PLANNING APPLICATION REPORT**REF NO:** LU/397/10/**LOCATION:** 26A Eagles Chase
Littlehampton**PROPOSAL:** Proposed 2 storey side extension (resubmission of LU/347/10/)**SITE AND SURROUNDINGS**

The proposed application seeks permission for a 2 storey side extension to the existing dwelling. The dwelling was formed as an addition to No.26 Eagles Chase to which LU/473/89 refers. The application is the resubmission of a previously refused application for a 2 storey side extension.

Plans & Elevations As Proposed

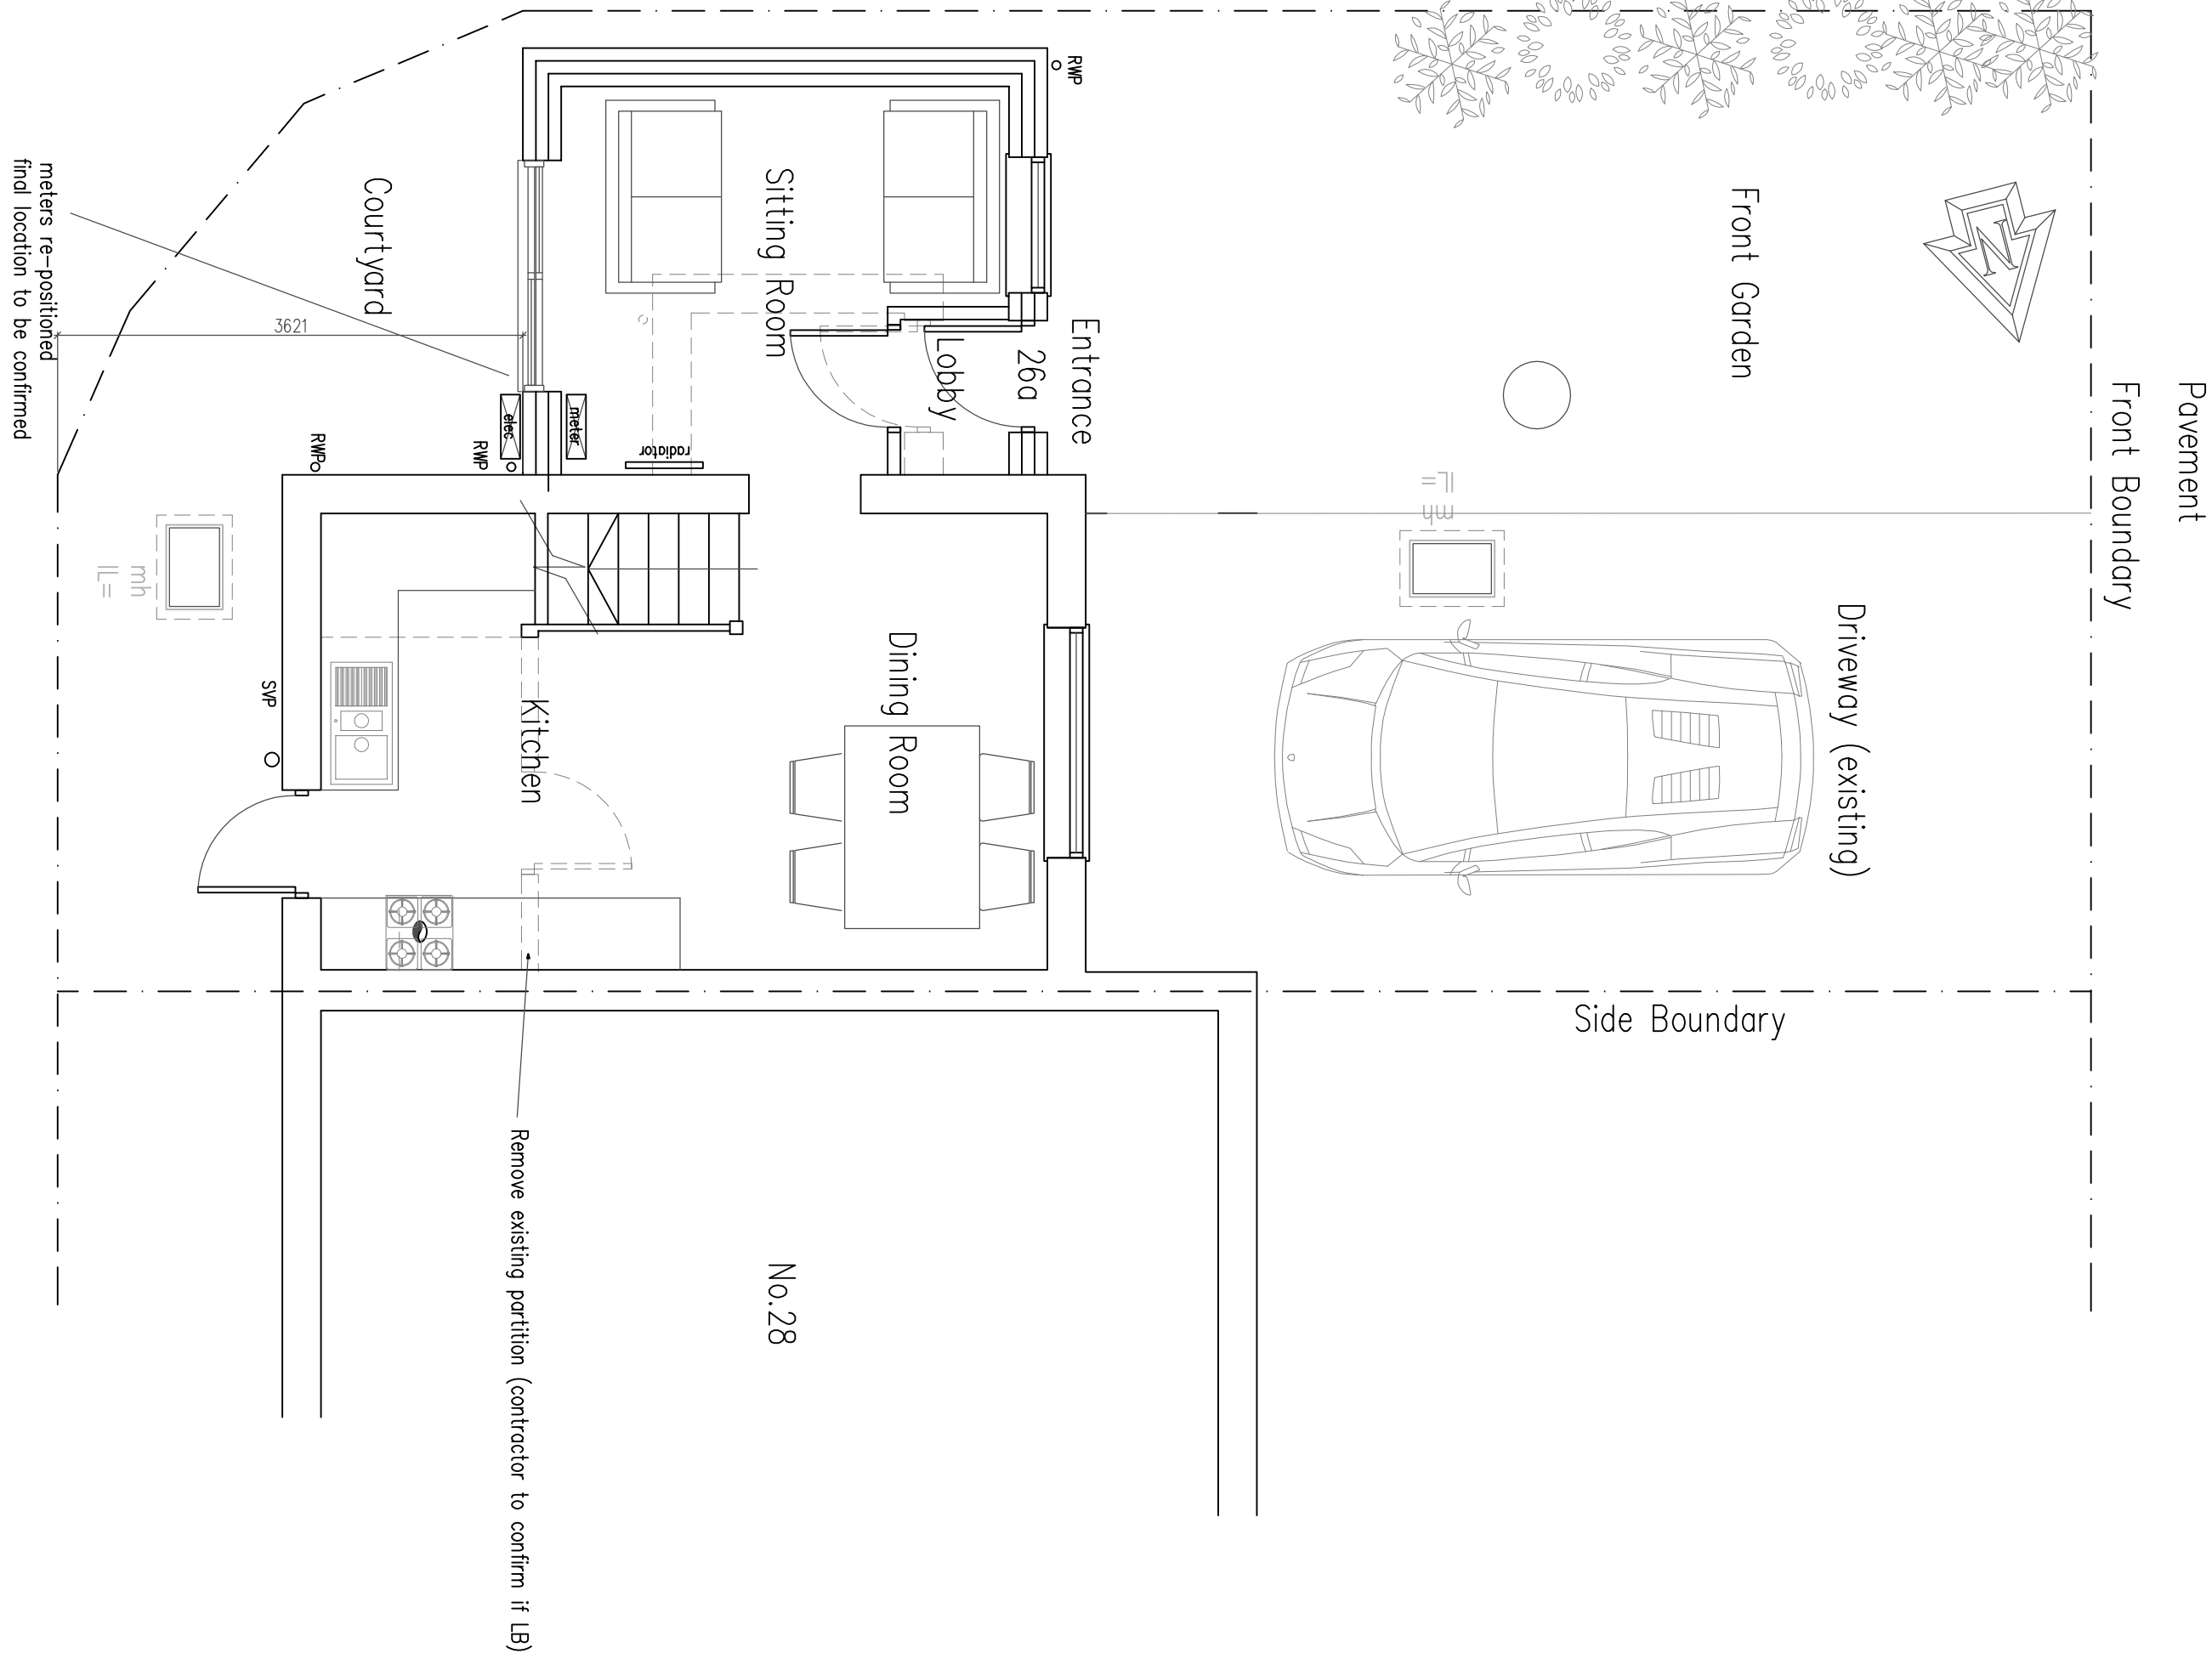
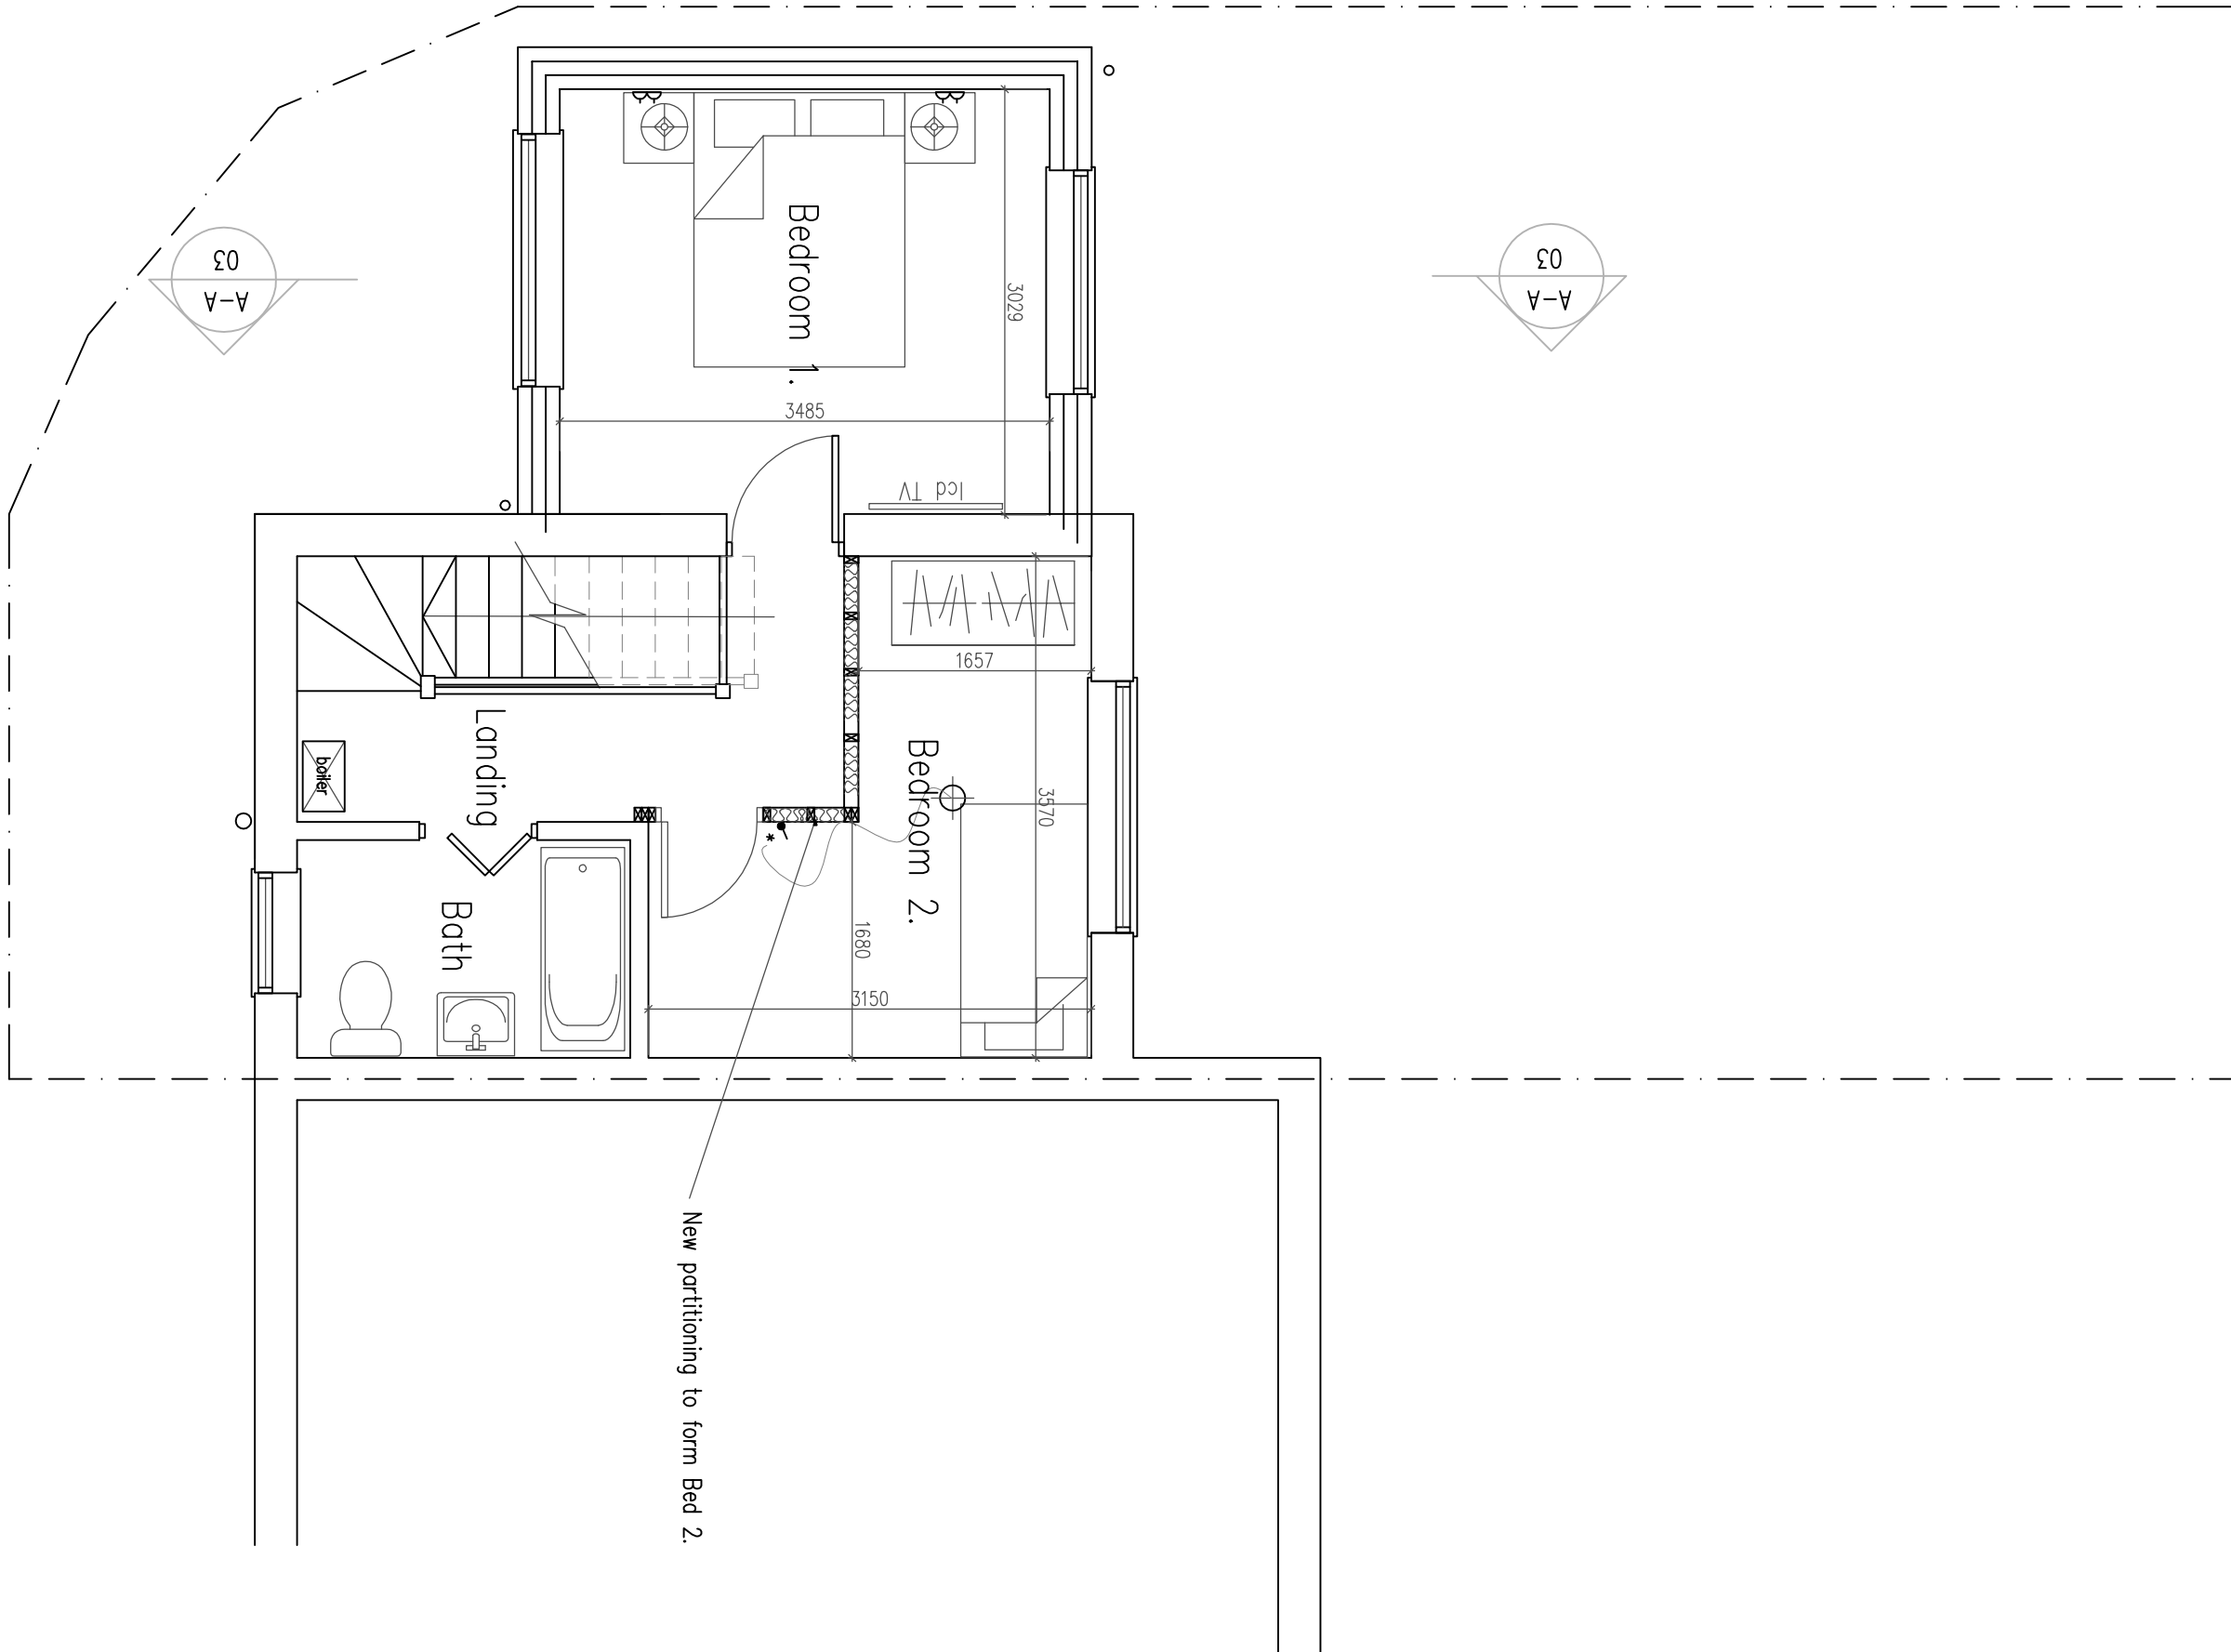
The proposed 2 storey extension has been reduced in depth and width to the application previously refused (LU/347/10/) therefore reducing the amenity area lost from the extension. Nevertheless, the proposal still extends close to the southern boundary of the site which forms the majority of the private amenity area to this 1 bedroom dwelling. Although there would be amenity area maintained to the front of the site, this is not considered to private amenity space and its use as a private amenity area would be totally out of keeping with the general layout and appearance of the street scene.

Further, given that the amenity area of the existing dwelling is significantly reduced to that of neighbouring properties within the locality as considered previously any further reduction would be out of character with others within the locality. Whilst the proposal does attempt to overcome the loss of private amenity space maintained, the area to the rear of the property is still considered to be inadequate for its intended purpose, detrimental to the private amenity of current or future occupants.

The current application reduces the scale of the side extension with a notable reduction to its depth. This attempts to overcome previous concerns with the extension not appearing visually subservient as well as appearing as a cramped addition out character with the street scene. However the scale of the extension is still comparable to the width of the existing dwelling which does not appear visually subservient to the host dwelling, therefore the further addition would continue to alter the appearance of the dwelling with an extension that is out character with the general layout and appearance of the street scene as well as not appearing visually subservient to the host dwelling.

- 2 The proposed side extension by way of its overall width and depth would significantly alter the appearance of the property forming an unsympathetic addition to an existing terrace which results in an extension that would not appear visually integrated or subservient to the existing dwelling and thereby would be detrimental to the appearance of the dwelling and the street scene. The proposal would therefore conflict with policies GEN7 and DEV19 of the Arun District Local Plan.
